Our ref: New Public School in Mulgoa Rise Mod 1 – Temporary Buildings (SSD-11070211-Mod-1)

**Subject:** Response to Submissions – Key Issues

## Attachment A – Key issues

Figure 4: Proposed Development and PMF Flood Extent.

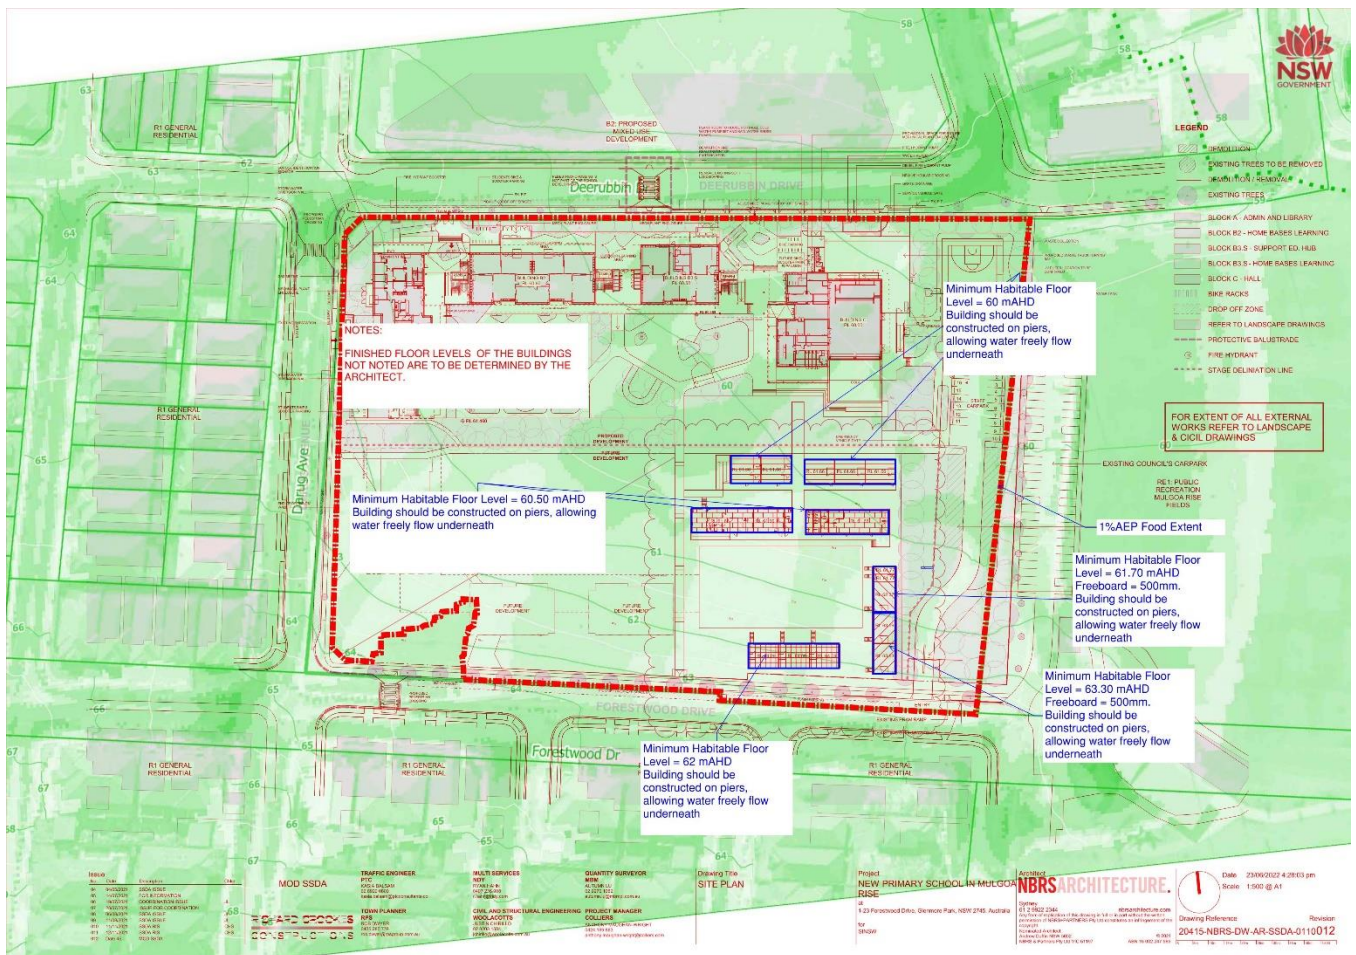
- assess the extent of overland flooding during a probable maximum flood event (PMF) and the subsequent impact on any temporary buildings proposed as part of this Modification Application;
- assess flood behaviour on-site and in the surrounding areas post-development of the proposed temporary buildings, for both the PMF and 1% Annual Exceedance Probability events. Clearly state whether the proposed temporary buildings would result in any additional flooding to surrounding properties; and
- provide details as to which Australian Standards and/or guidelines, that any buildings impacted by overland flooding will be constructed to, to withstand overland flooding and minimise the risk of death or injury to occupants and damage to property.

Drawing Reference  
**20415-NBRS-DW-AR-SSDA-0110012**

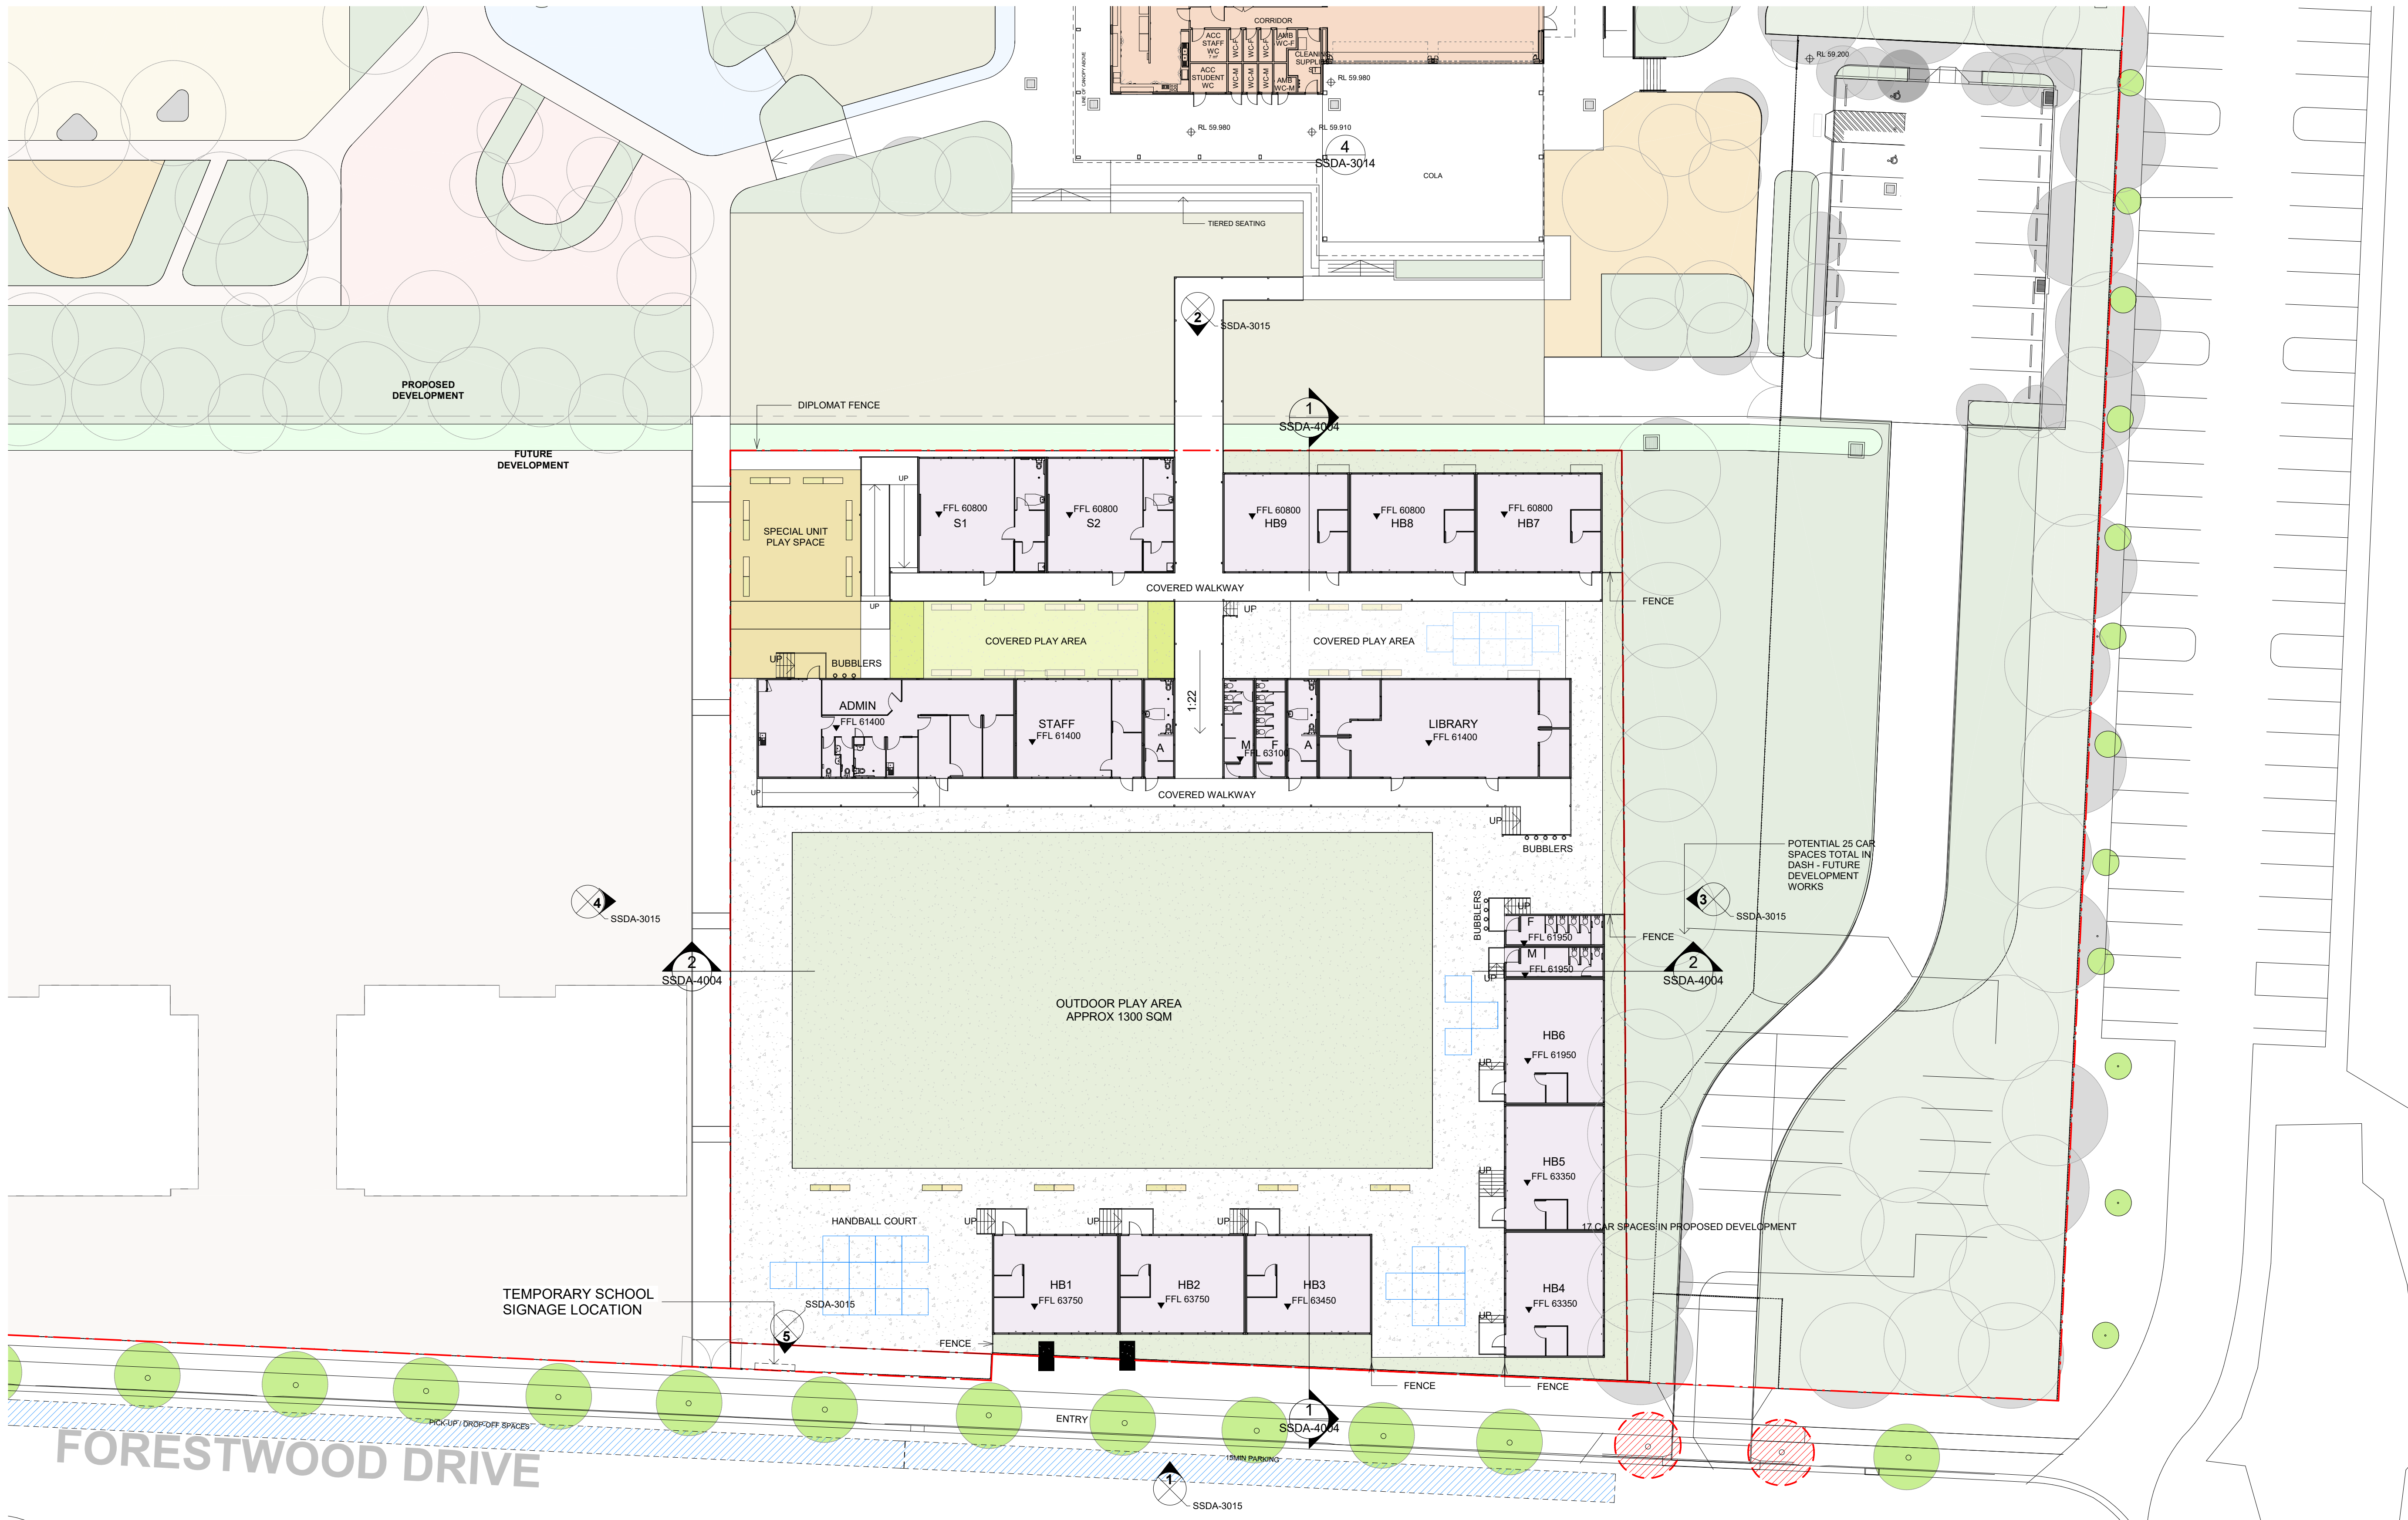
The Department has reviewed the Modification Report and advice provided by EHG and notes that one existing tree on Forestwood Drive is proposed to be removed. It is not clear on the landscaping plans submitted which tree will be removed. Please confirm and provide revised plans detailing:

- which existing street tree will be removed on Forestwood Drive or otherwise;
- the species of any tree proposed to be removed; and
- if proposed, the location, species, height and age of the replacement tree.
